2 November 2009

**Major Project Application MP09_0011
Garvan St Vincent's Cancer Centre
Response to Submissions**

JUNE 21 - 9:00 AM

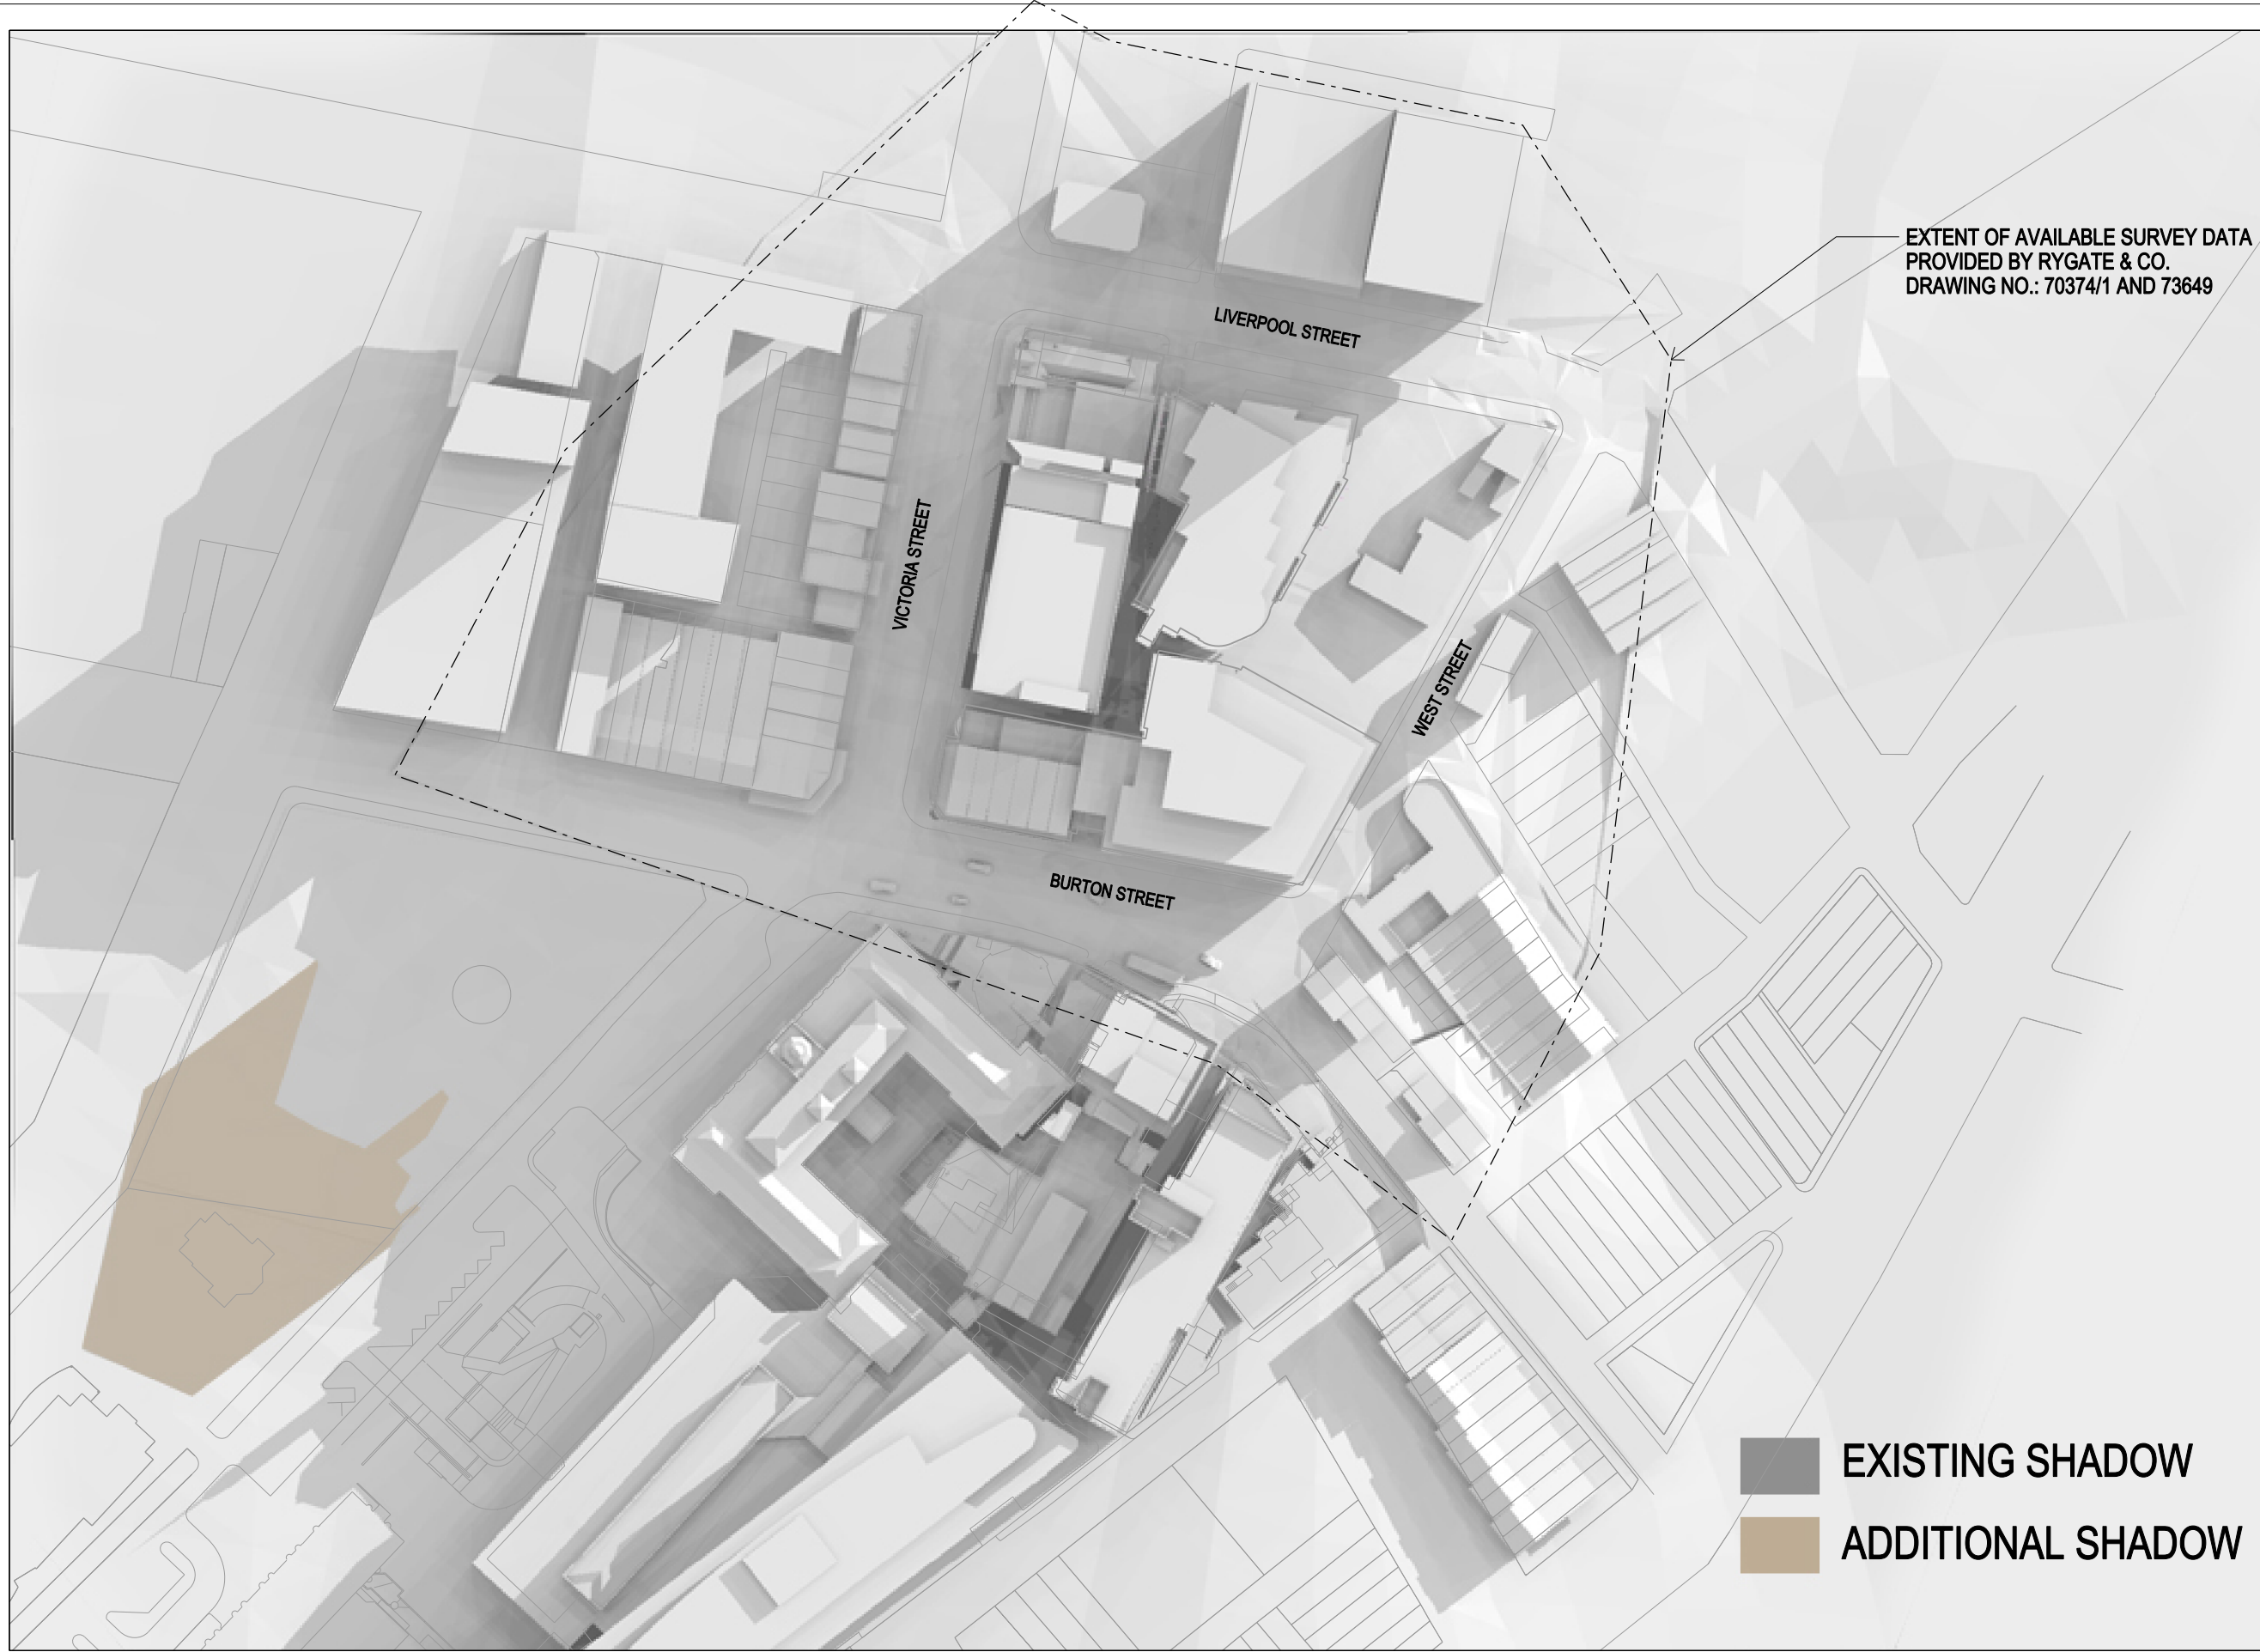
(c) *The overshadowing and overlooking analyses lack credibility. It can be deduced that the overshadowing effects over the residential areas east of West Street will be significant in the afternoon throughout most of the year and more extensive than the one day of the year chosen to be illustrated in the Report (equinox and other time impacts are not considered). Overshadowing impacts to Green Park in the early hours of the day are considered unacceptable;*

The project Architects who produced the shadows diagrams have advised that Shadow drawings were generated using Microstation software, based upon survey information provided by Rygate & Company Limited (Dwg No. 73649 - Showing contours & DTM surrounding the site and EX_71194_RevF - Showing the existing buildings on site)

A 3D net was constructed which accurately represents the information provided by the surveyor relating to the topography of the site.

All modelled information was set to the surveyors True North in the Microstation model and all existing buildings where survey information was available were modelled to survey ridgeline, gutter or parapet line and to survey outline. All buildings, including the proposed scheme were projected from RL 0.0 to the corresponding survey RL or intended RL, as reflected on BVN elevations and sections for the Project Application. Sun angles and sun angle projection were based on sun angle projection software that is built into Microstation.

As the city would be aware, the "one day of the year chosen to be illustrated" is the Winter Solstice, which is the day of the year on which shadows are longest and shadow impacts therefore the most extensive. Throughout the rest of the year, shadow impacts will be less extensive than indicated. Should the Department of Planning see any purpose in considering other dates, diagrams for these dates can be provided.
